**NORTH EVELEIGH AFFORDABLE
HOUSING**

ACCESS REVIEW

Morris-Goding Accessibility Consulting

4 April 2013

drawing no. DA01-002 issue A

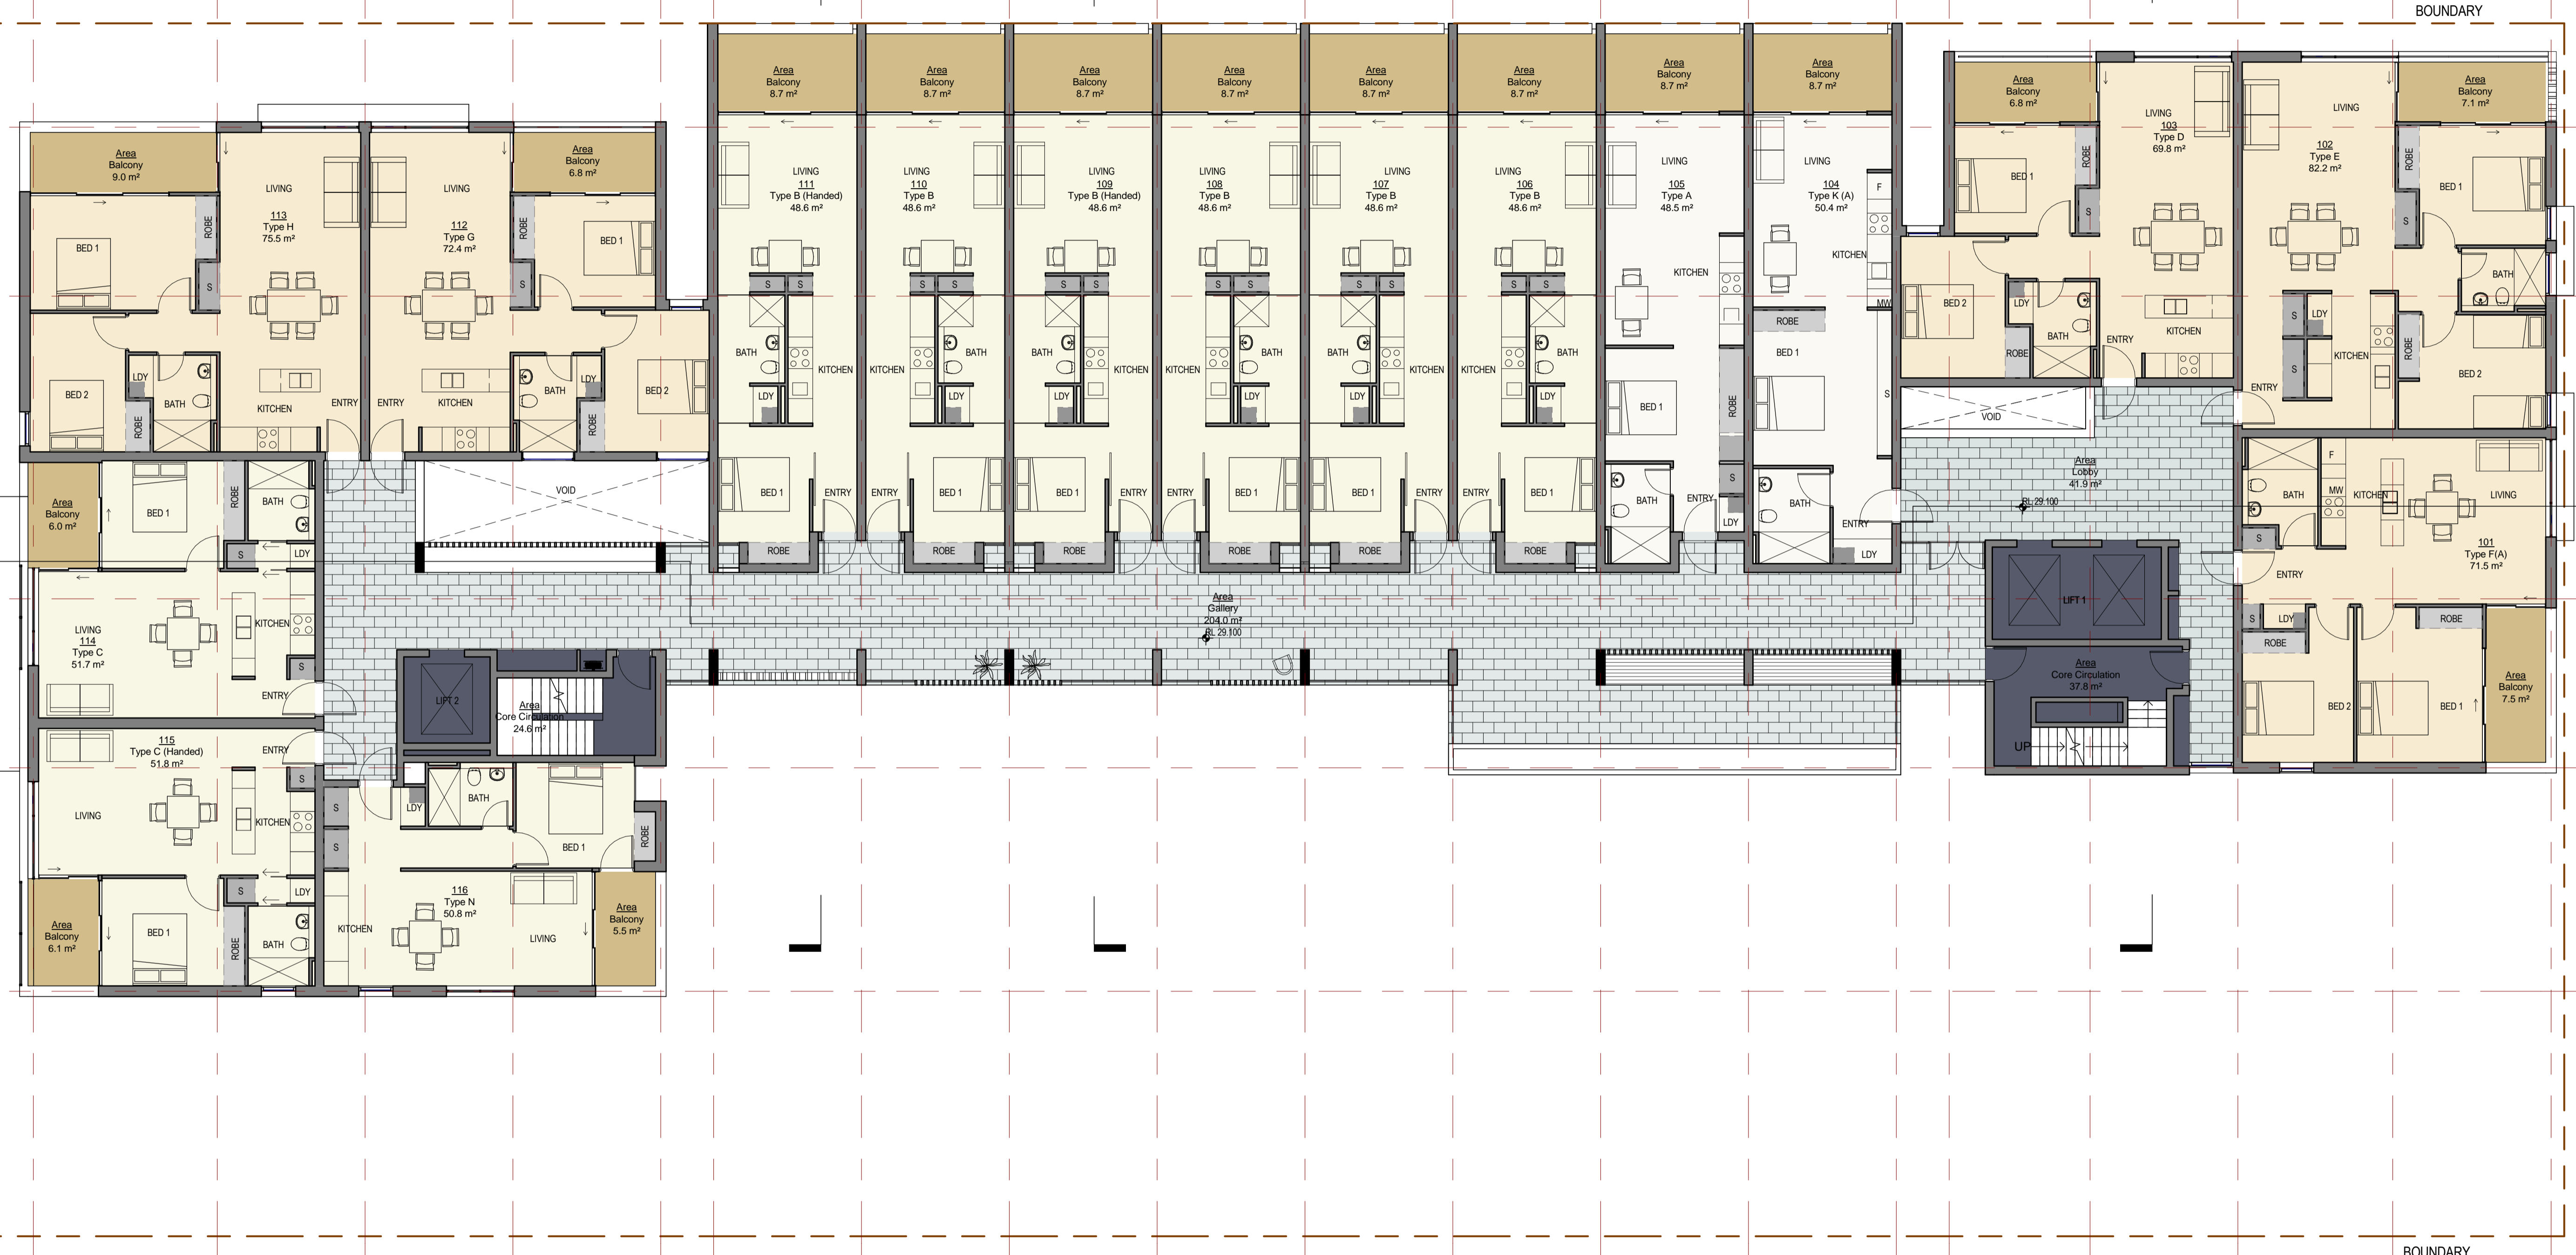
- (i) The main entry stair requires handrails, TGSi and nosings in accordance with AS1428.1
- (ii) The entry ramp requires handrails and TGSi designed in accordance with AS1428.1.

The secondary entrance is from the south of the proposed building. Whilst the door has an accessible path leading to it, once inside the doors there is a set of stairs that renders the entrance inaccessible.

The concession in the DDA Premises Standards allows an entrance to be inaccessible as long as it is no more than 50 metres from another accessible entrance. In this case, the secondary entrance is 70 metres from the main entrance and thus the concession does not apply.

- (i) This entrance will require ramp or lift access to comply with DDA Premises Standards

drawing no.	issue
DA09-001	A

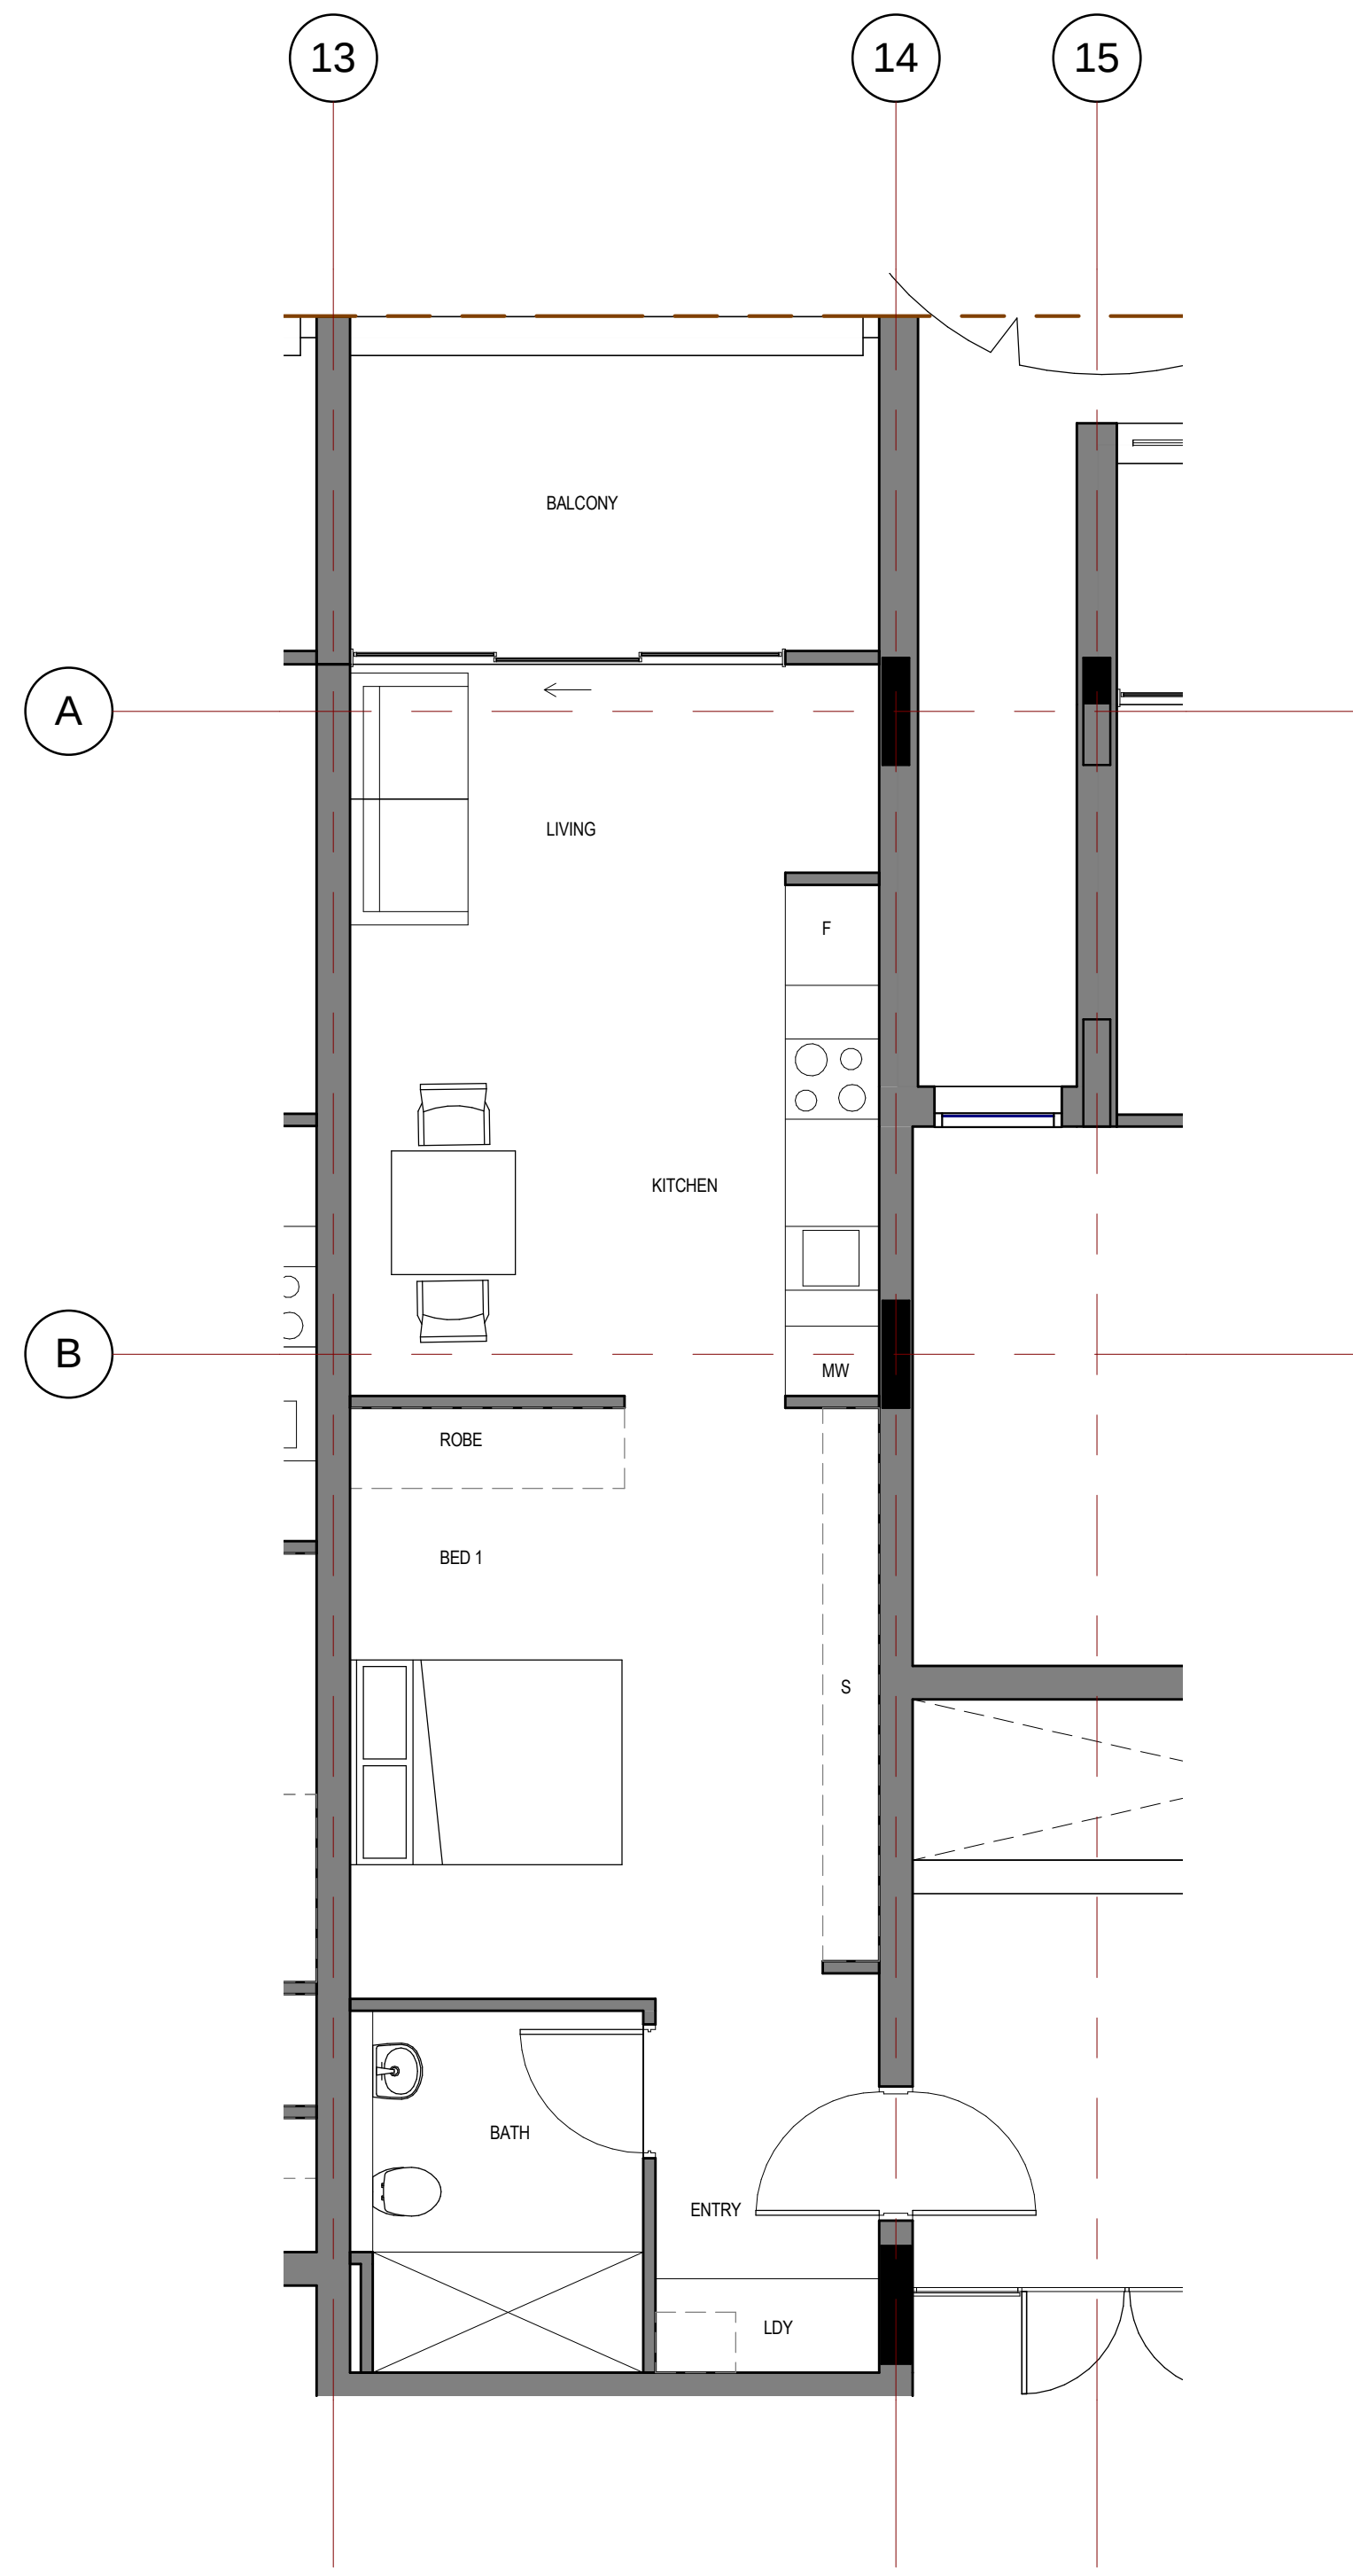
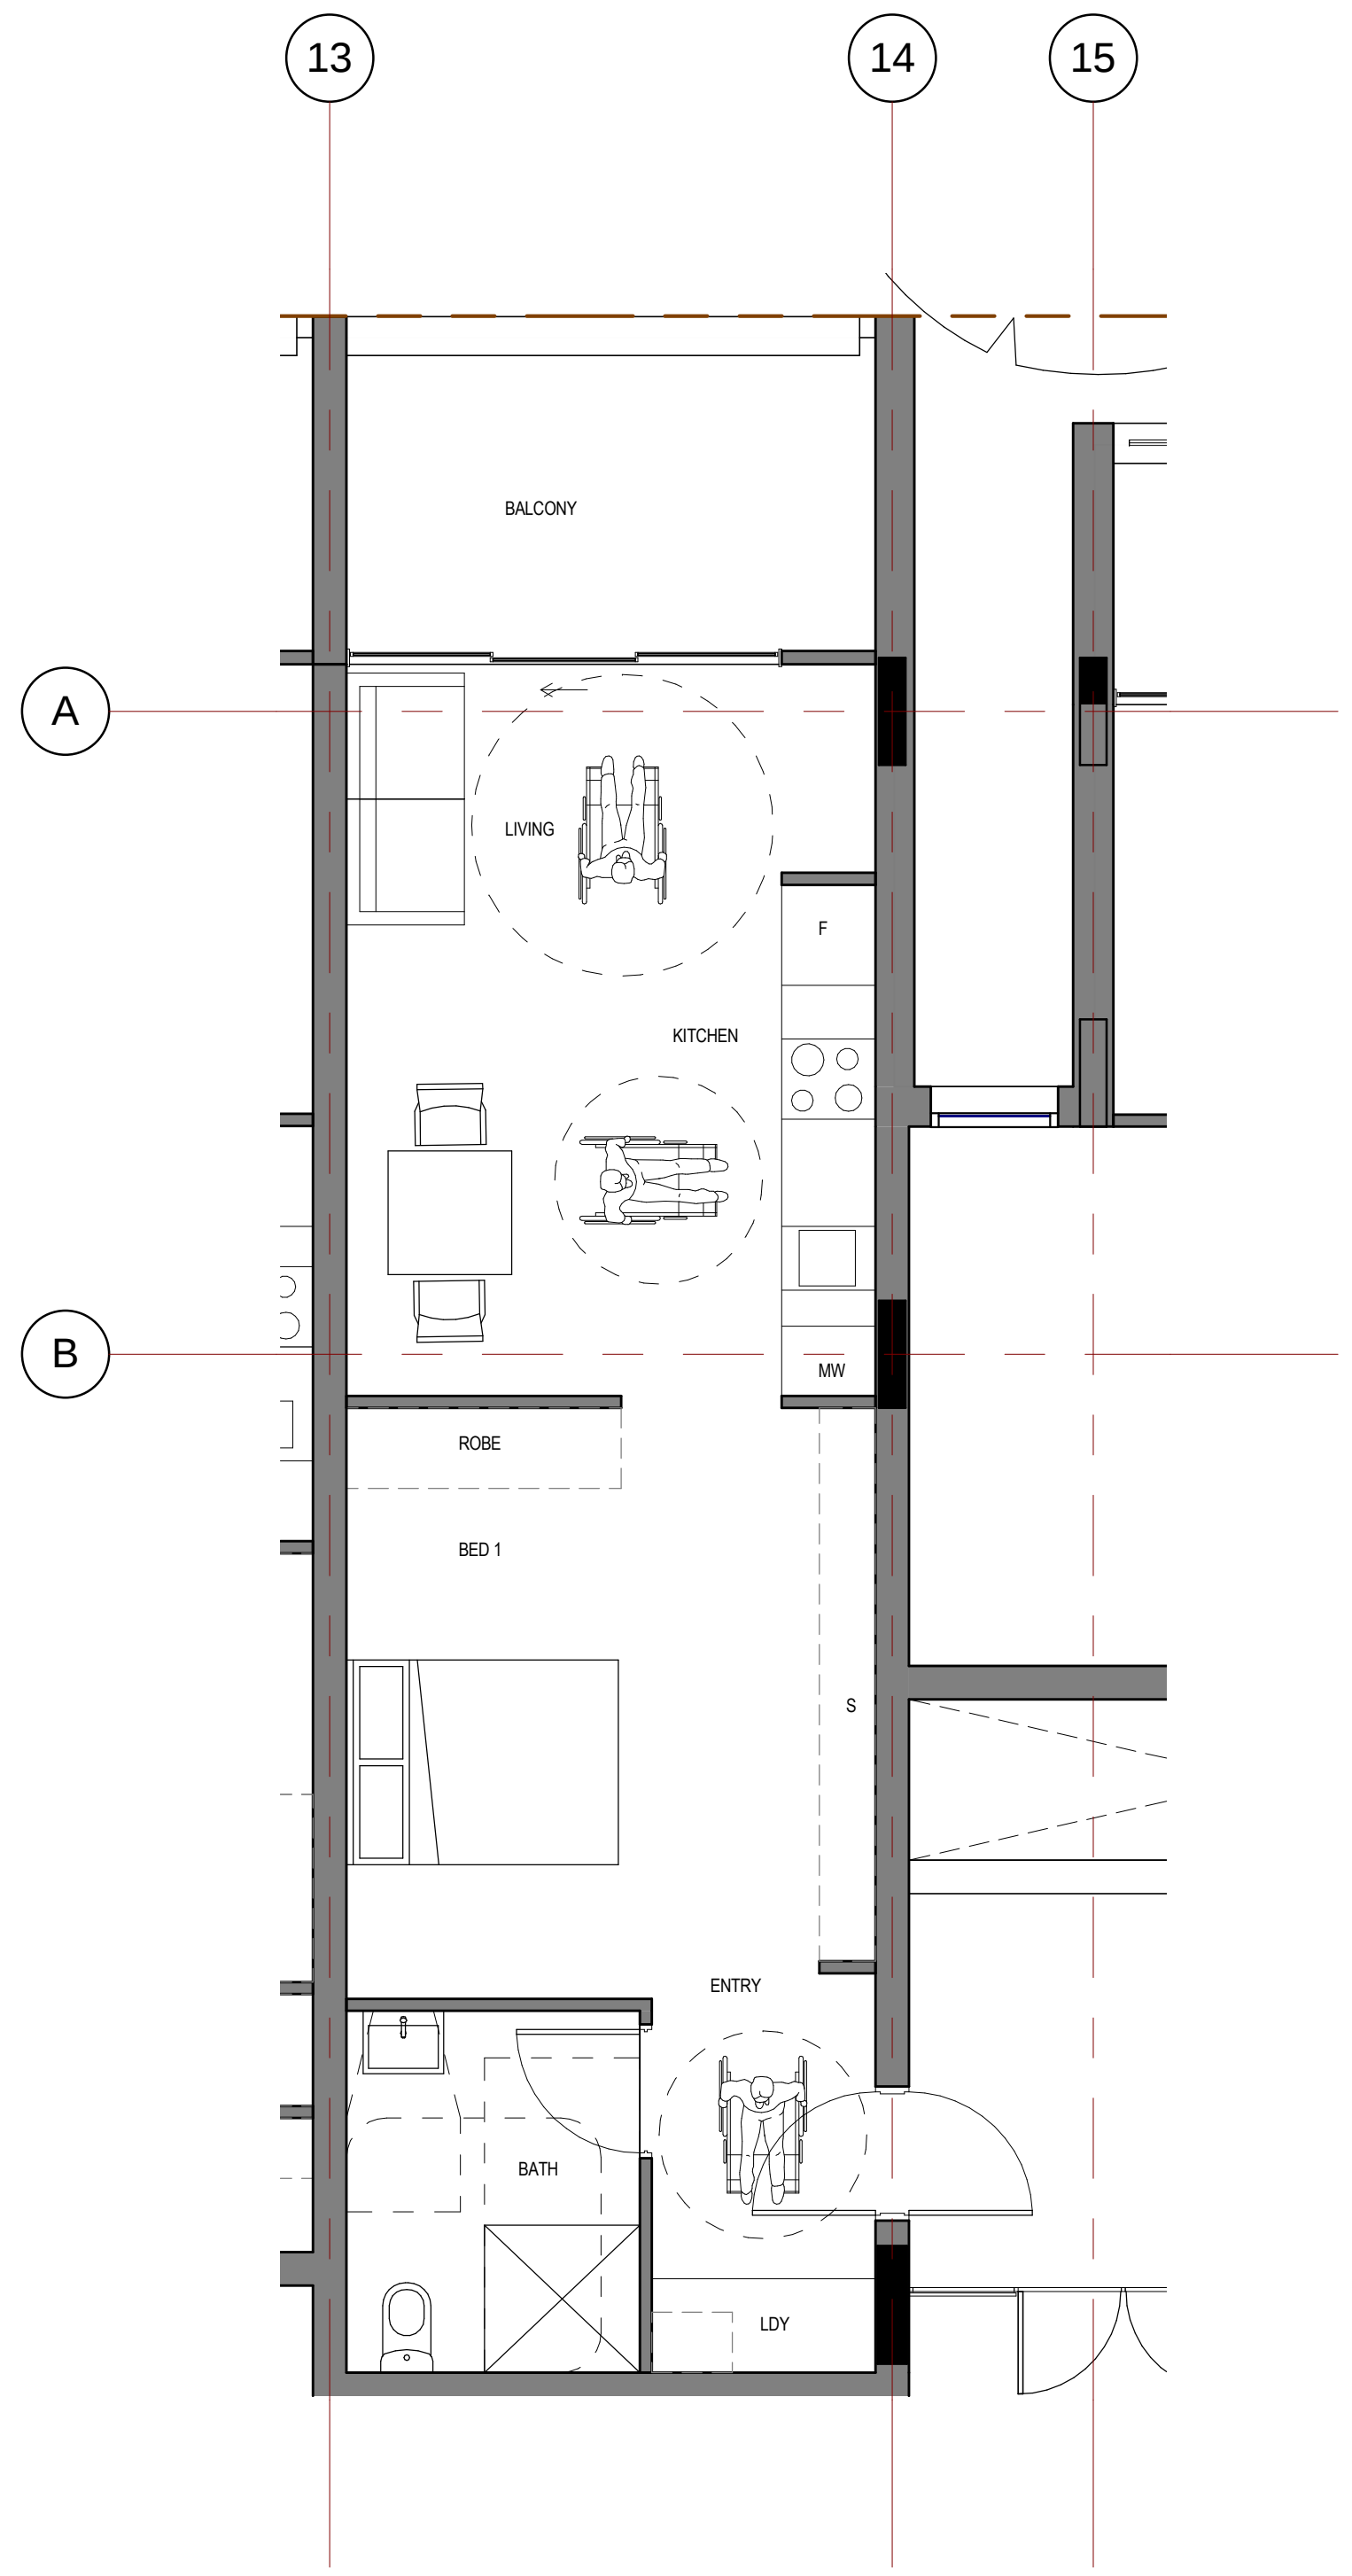
- (i) Ensure the kitchen has appropriate work bench space adjacent to refrigerator, cook top and sink under AS4299.
